LATTA ENGINEERING, PLLC

**Re: Incomplete Application Letter – PA22-019
Groundhog PRD, 83 Avenue NE, Marysville, WA**

Latta Engineering Ltd (LE) has prepared this letter to address your *incomplete application* determination dated May 18, 2022 (see attached copy of your incomplete application letter for reference).

**COVER SHEET**  
GROUNDHOG PLANNED RESIDENTIAL DEVELOPMENT

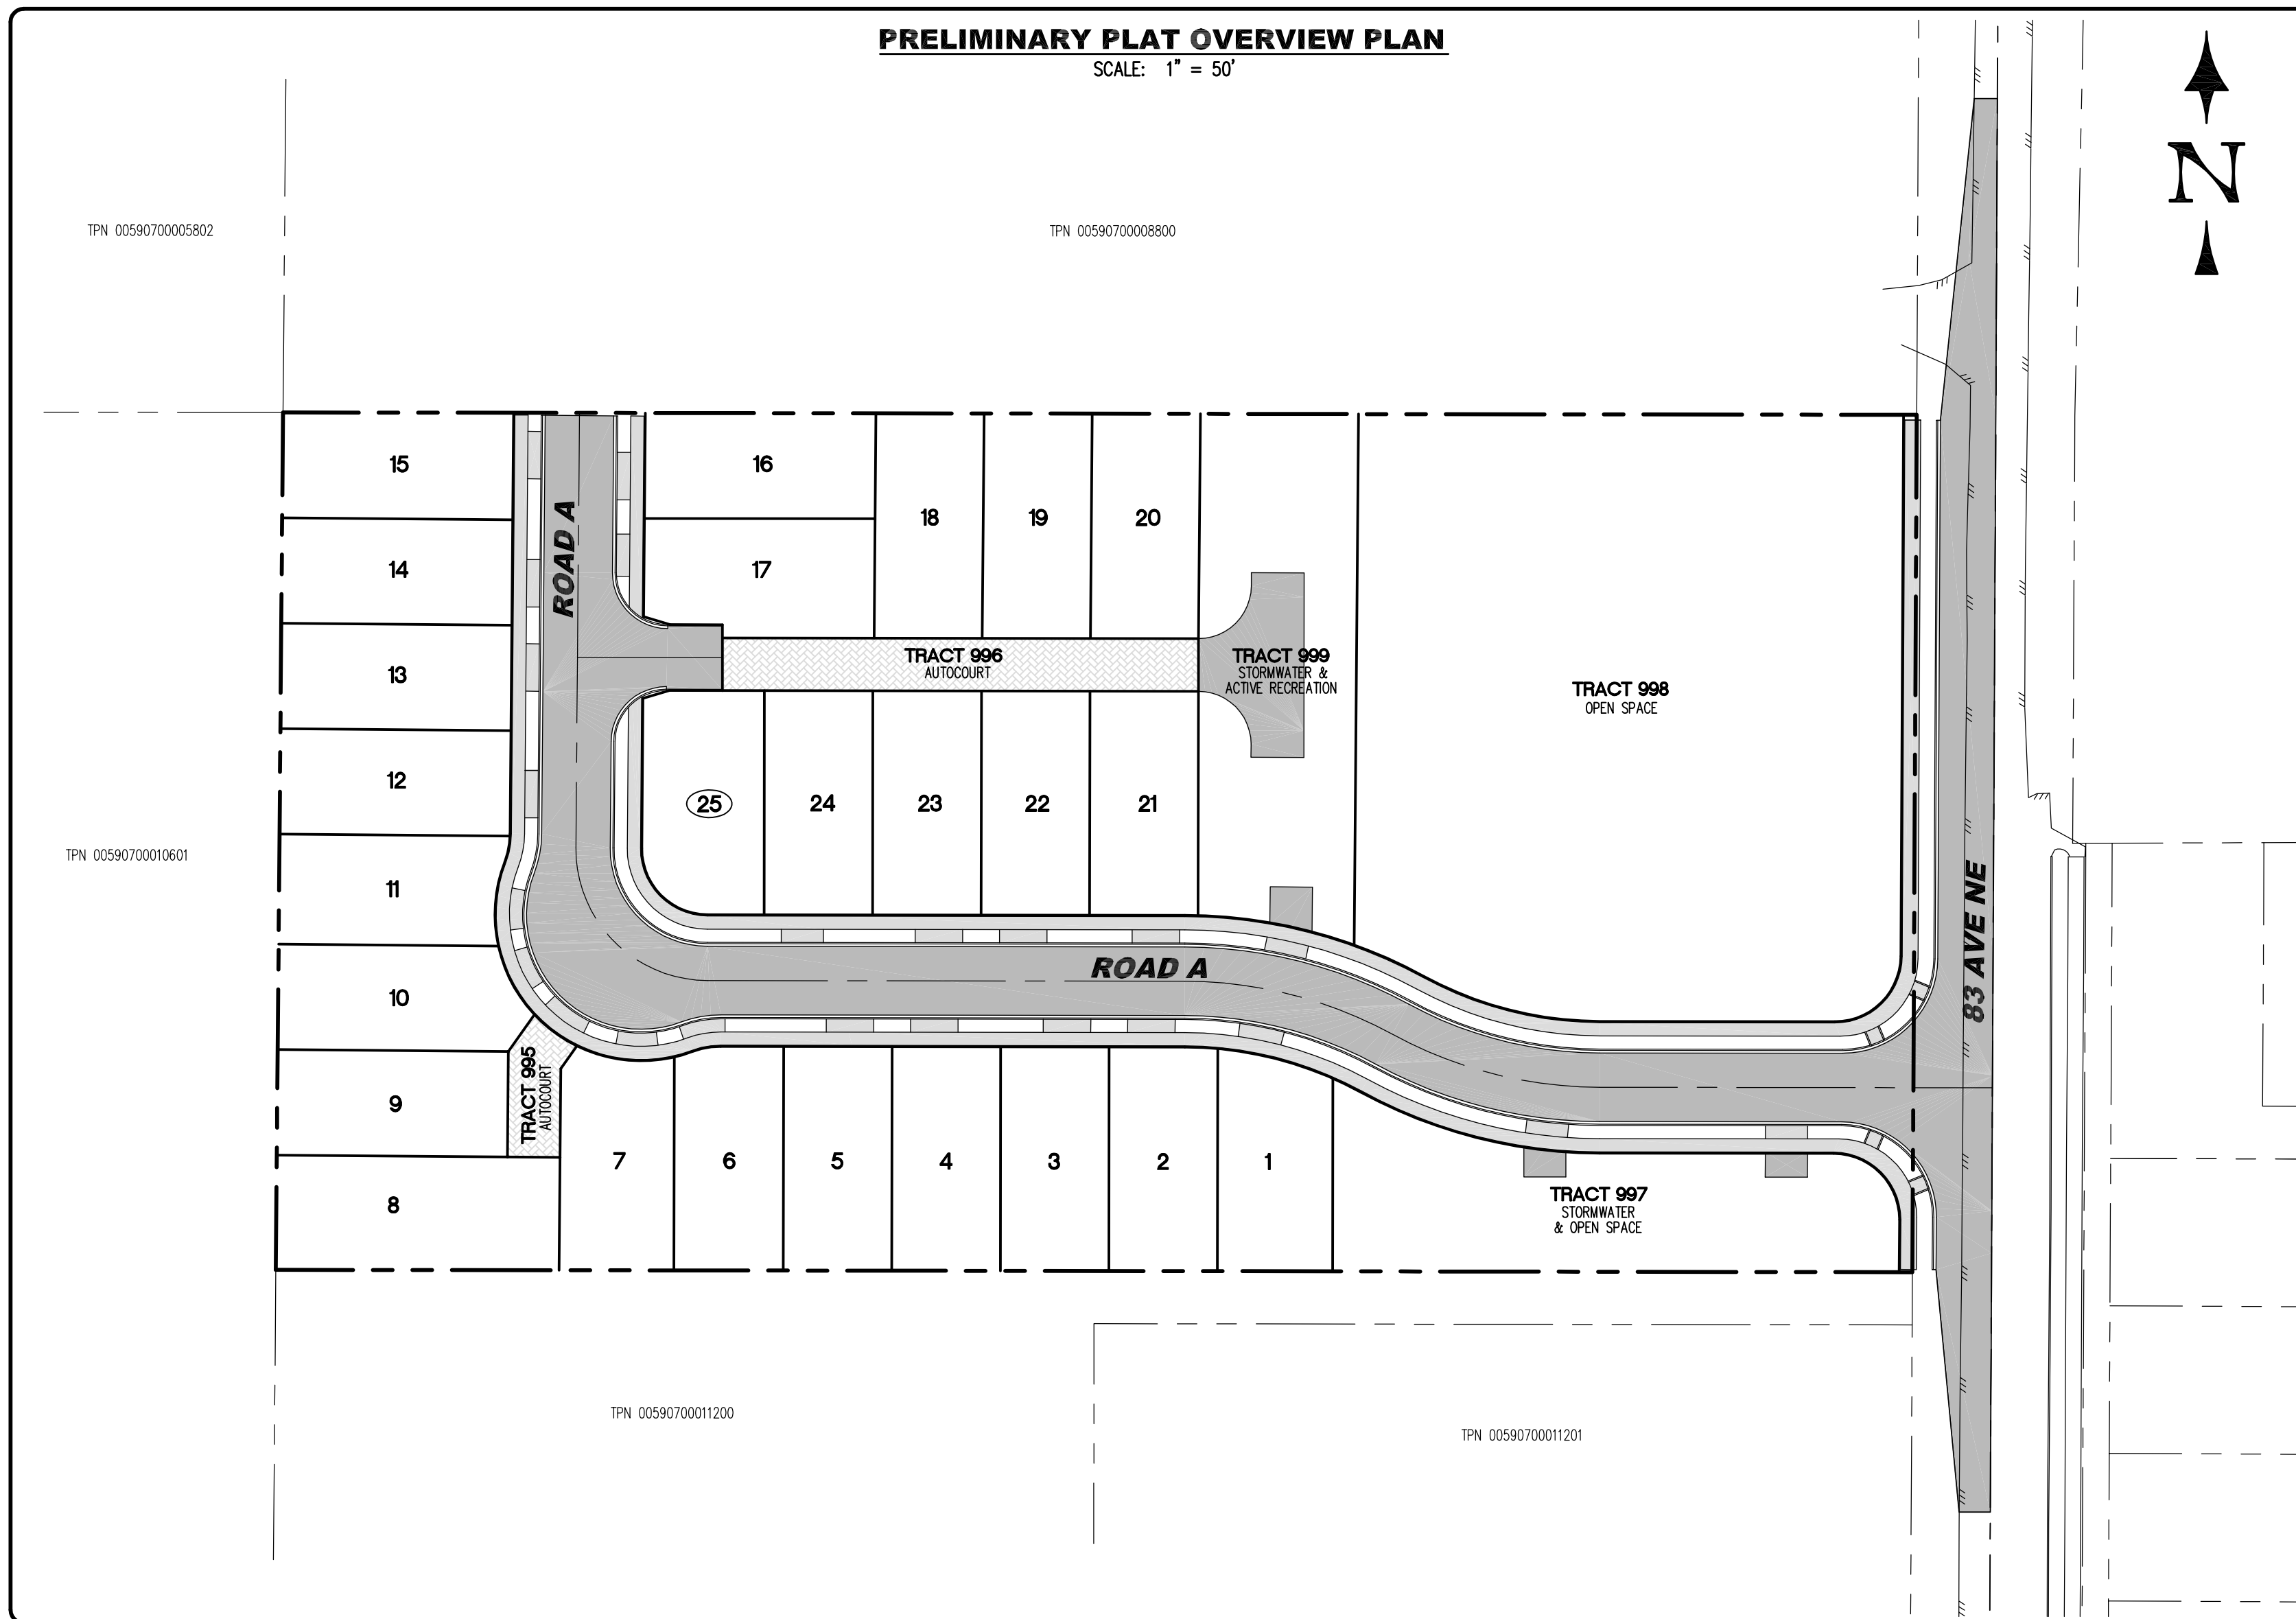
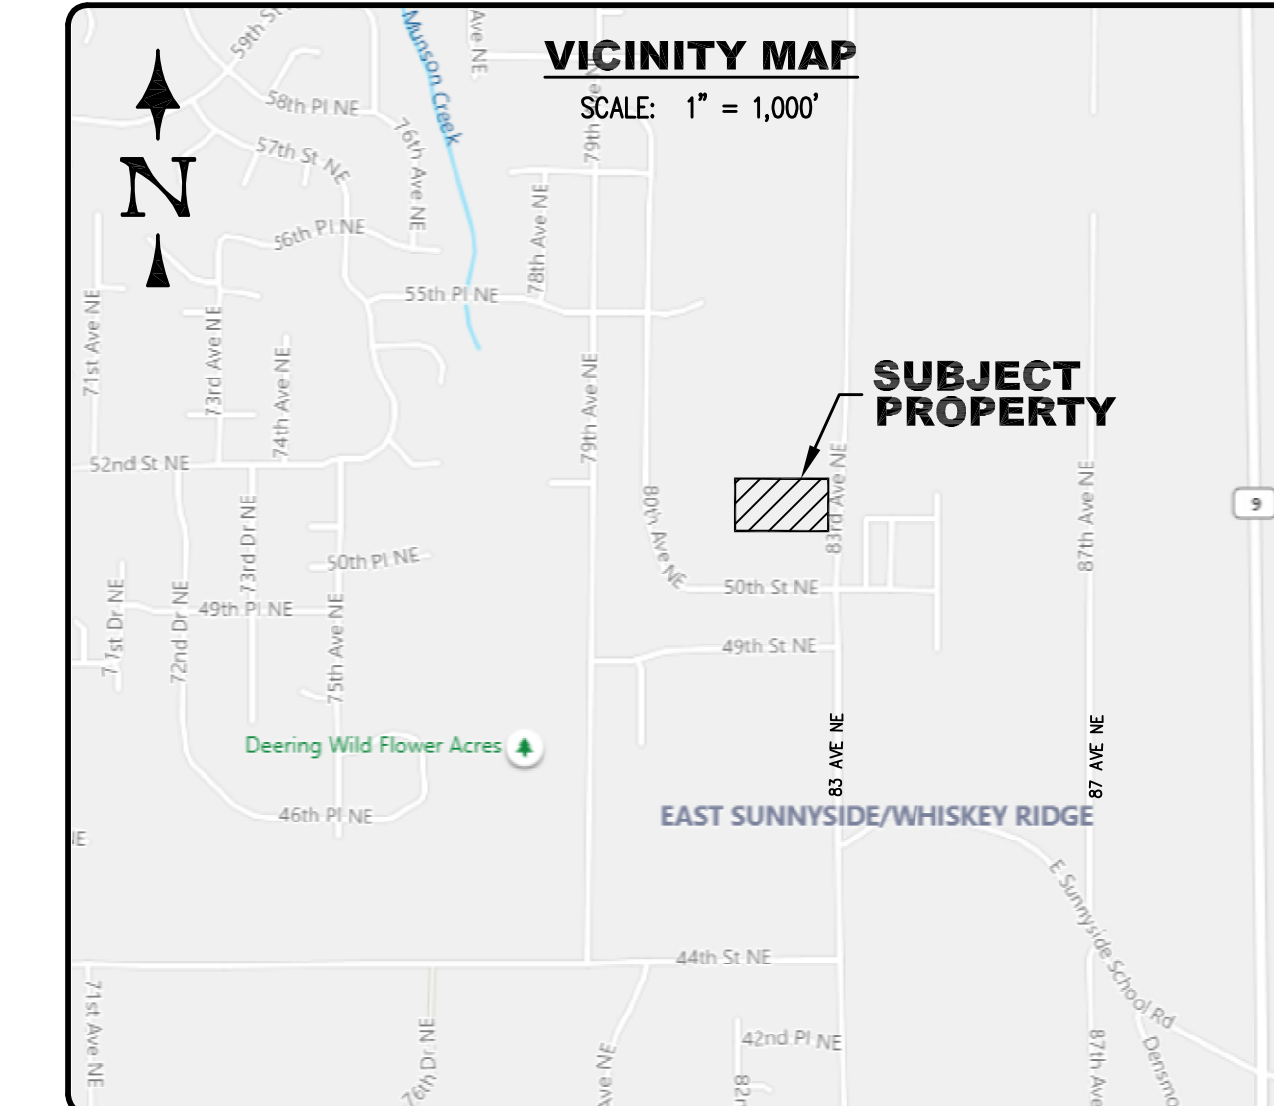
3. As indicated in the project narrative, bonus density is proposed via Residential Density Incentive (RDI) 6a. Clarification is needed to demonstrate compliance with the application of said RDI. As proposed, the active open space does not meet the definition of MMC 22.090.040. Please provide clarification as to what distinguishes the open space as “active”.

- o This PRD application only requires a single RDI credit (1 unit) to achieve the proposed density of 25 lots.
 - o The application includes a dual use storm detention tract (Tract 999) however the preliminary landscape plan currently proposes only passive recreation (RDI-6b) on this tract. Moreover, RDI-6b provides 2 bonus units per acre of the storm water facility tract used for passive recreation (0.263 Ac x 2 = 0.526 units). If the applicant chooses to modify the landscape plan to include either playground equipment or a multipurpose sports court, Tract 999 would satisfy the active open space definition per MMC 22.090.040.

- o To ensure sufficient RDI credits are provided for this application, the applicant is also proposing perimeter fencing (RDI-7c) along the PRD boundary (810 LF of fence along the PRD west and south property boundary (Lots 1 through 15), and 210 LF of fence along the PRD north property boundary (Lots 16 through 20 and Tract 999)). Moreover, RDI-7c provides 1 bonus unit per 500 LF of perimeter fencing (1,020 LF / 500 = 2.04 units).

- o In summary, the Residential Density Incentives proposed (RDI-6b and RDI-7c) exceed the minimum RDI requirements for this project. An updated RDI summary is provided on the revised Civil Plan Sheet C-1 (see attached).
